Rezoning Transportation Analysis

Petition Number: 2020-45

General Location Identifier: Parcels 09104101, -02, and -03 on Bearwood Ave.

**Bearwood Ave
Rezoning Site Plan**

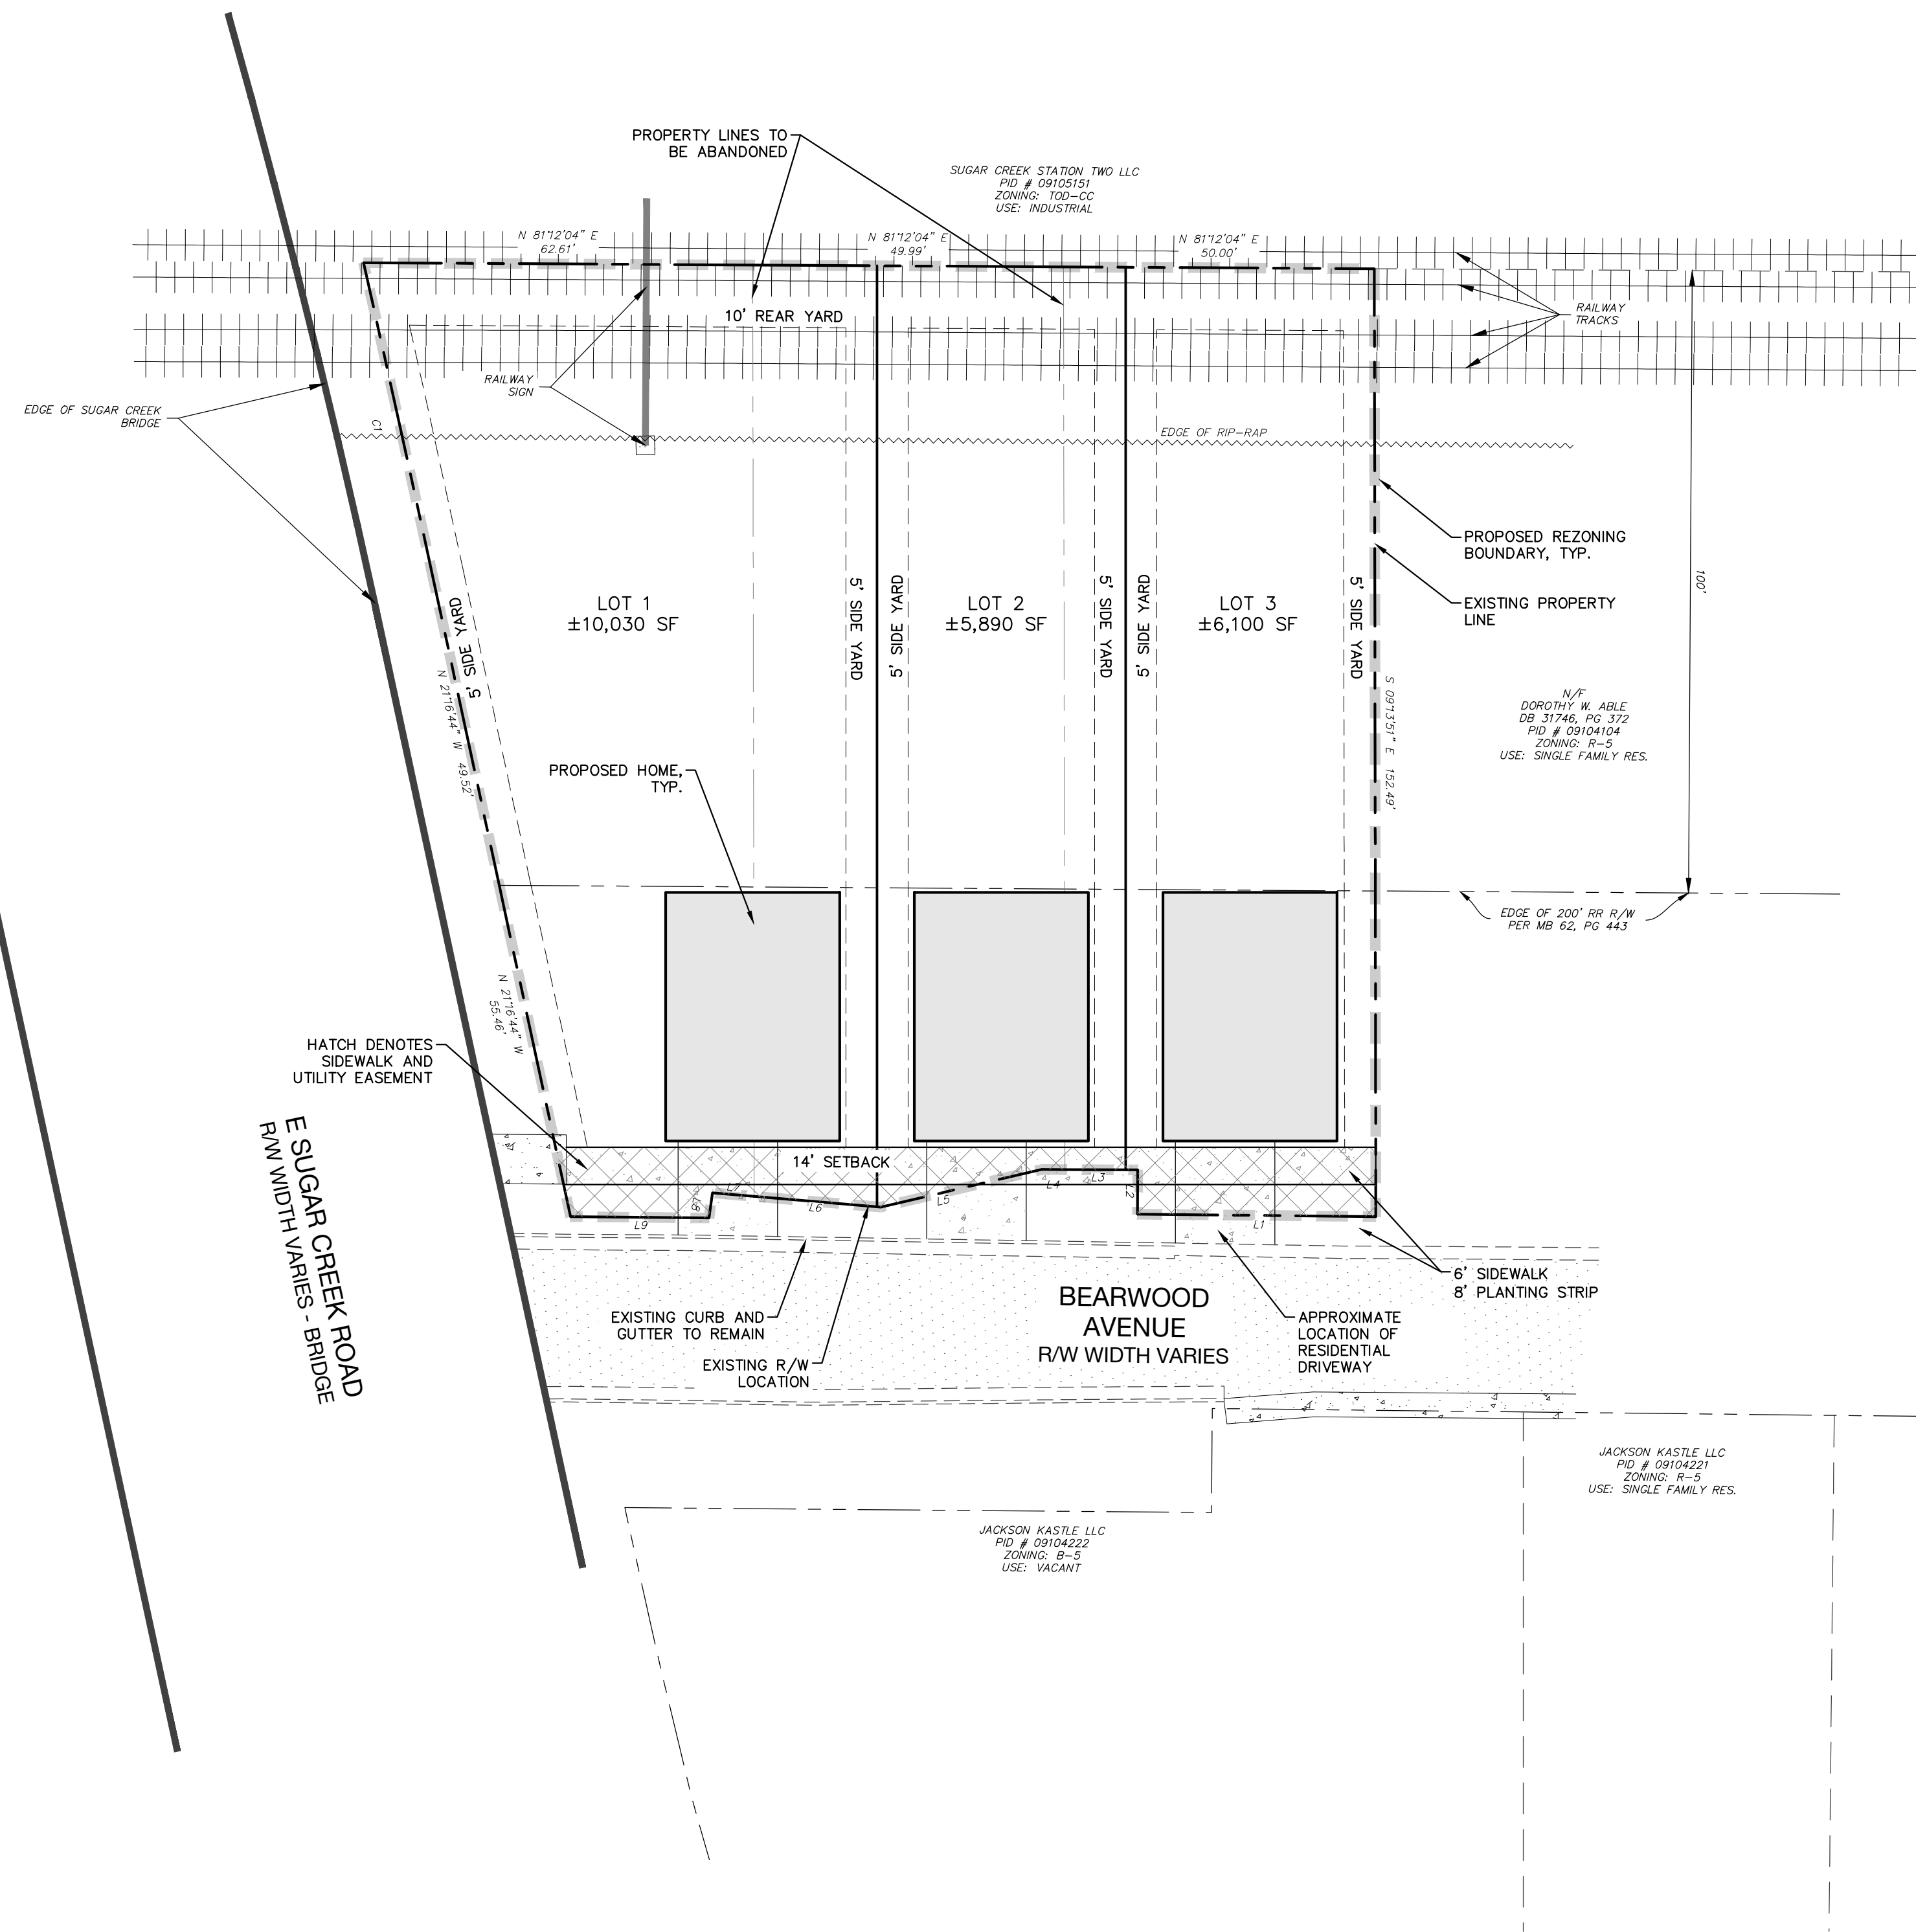
The site plan should show the curb and gutter labeled and dimensioned from the centerline for each road.
- ~~2. **Traffic Study** A Traffic Impact Study is not necessary for the complete review of this petition. If the during the permitting process the site generates more than 2,500 daily trips, then a traffic study will be required.~~

- ~~3. The right-of-way line for Bearwood Ave. should be revised to be a consistent dimension from centerline.~~
- ~~4. The petitioner should revise the site plan and conditional note(s) to adjust the proposed building footprints to ensure that there is a minimum of 20 feet from the garage to the back of sidewalk or back of right-of-way, whichever is greater, as required by the Zoning ordinance. If the railroad right-of-way precludes adjustments to building footprints, suggestions for providing parking include providing shared parking in the rear of Lot 1, and providing recessed parallel parking on Bearwood Ave.~~

- ~~5. The petitioner should revise the site plan to add a note specifying dedication and fee simple conveyance of all rights of way to the City before the site's first building certificate of occupancy is issued. CDOT requests right of way set at 2' behind back of sidewalk where feasible.~~
6. **Resolved** ~~Sample format for comment that is resolved~~
